COUNTY COUNCIL'S RESPONSE TO CONSULTATION ON THE FOLLOWING DEVELOPMENT PROPOSAL

Application No: 19/00400/REM

Proposal: Reserved Matters to 10/01642/OUT - Dorchester Phase 8A, comprising the provision of twenty four affordable residential units with associated landscaping, car parking, infrastructure and external works

Location: Heyford Park Camp Road Upper Heyford Bicester

VEHICLE TRACKING LAYOUT

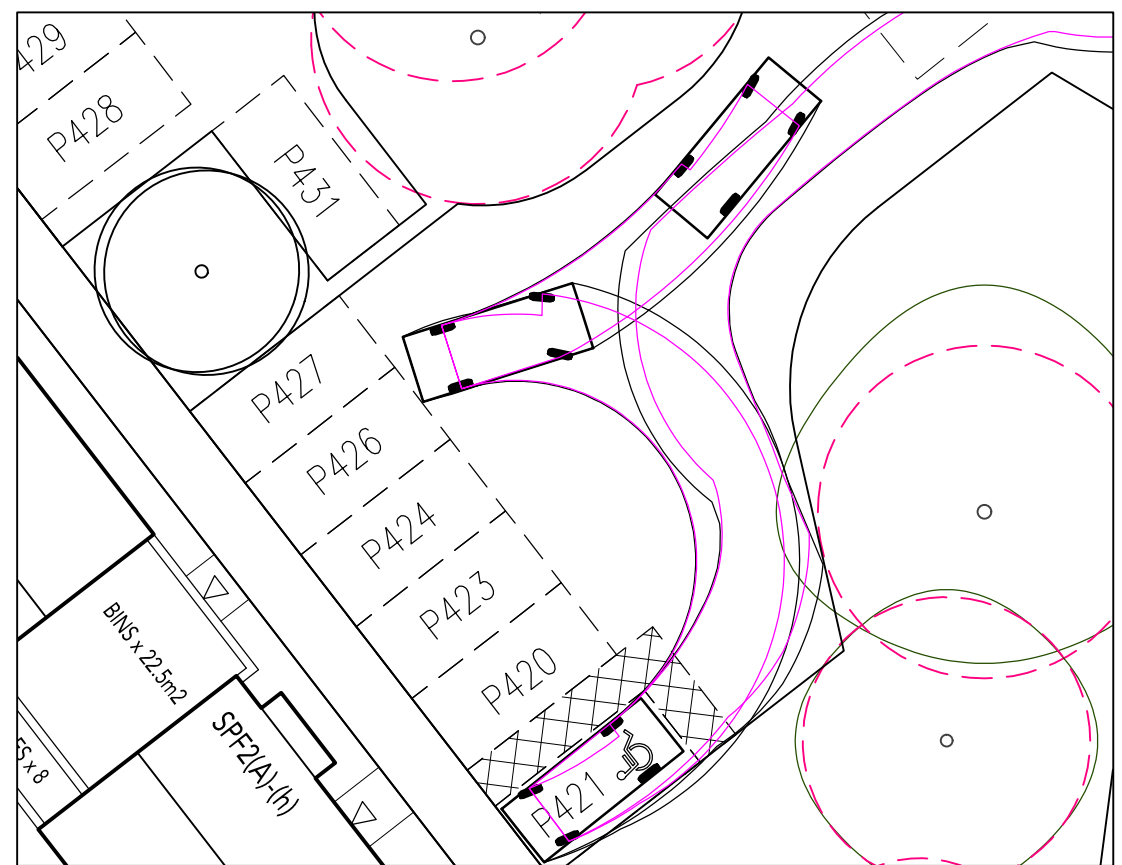
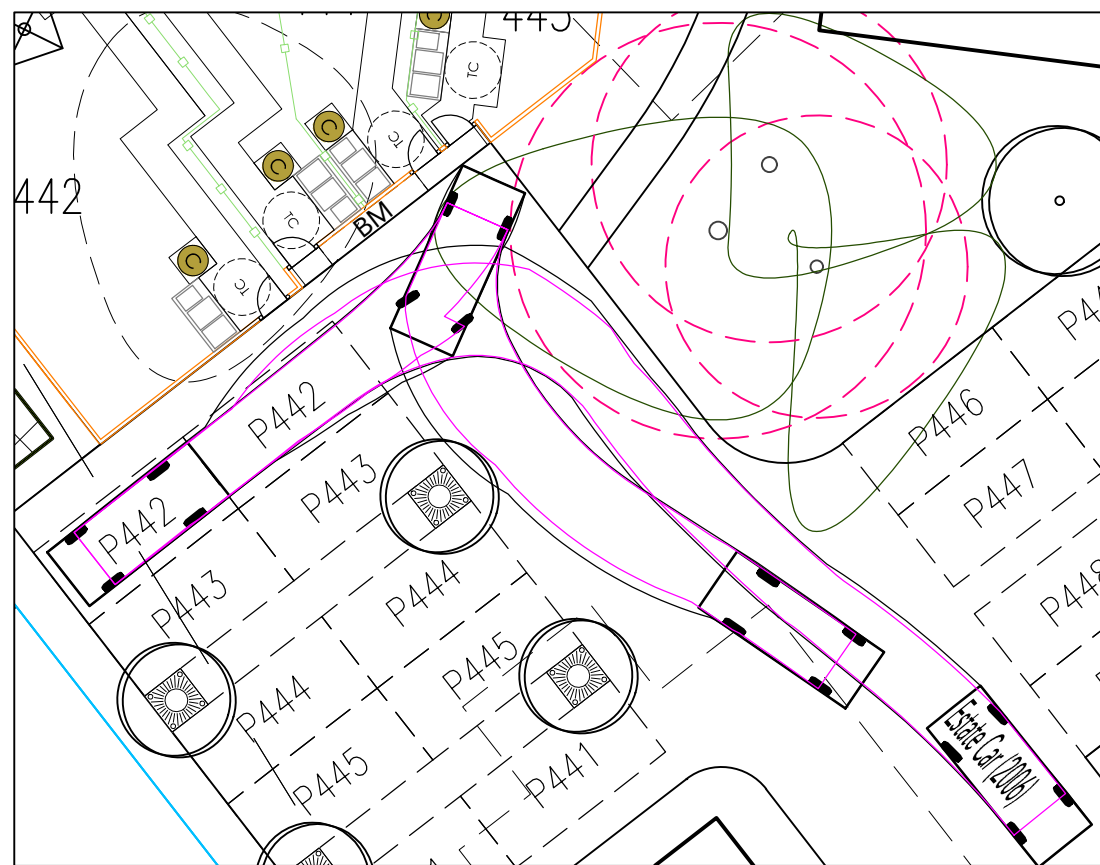
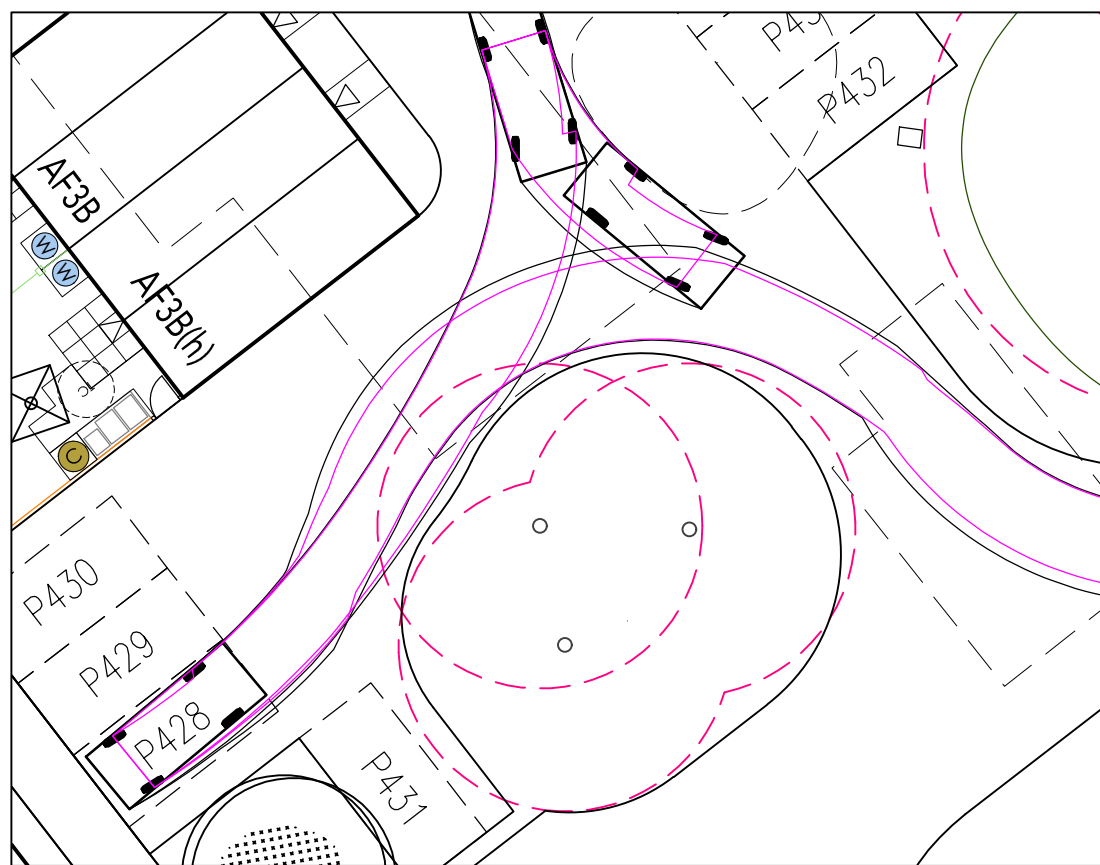
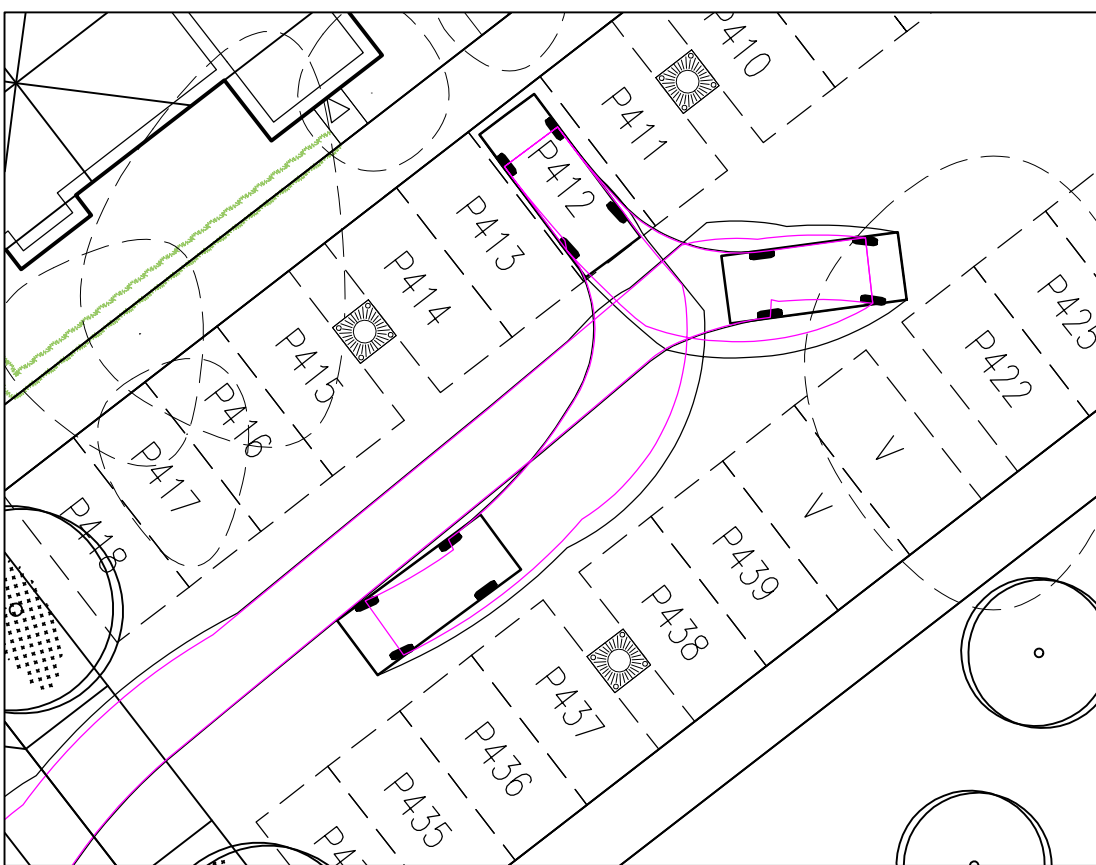
The tracking shows some large areas of body overhang and overrun of kerbs which is not acceptable. This should be adjusted. **Reason for objection.**
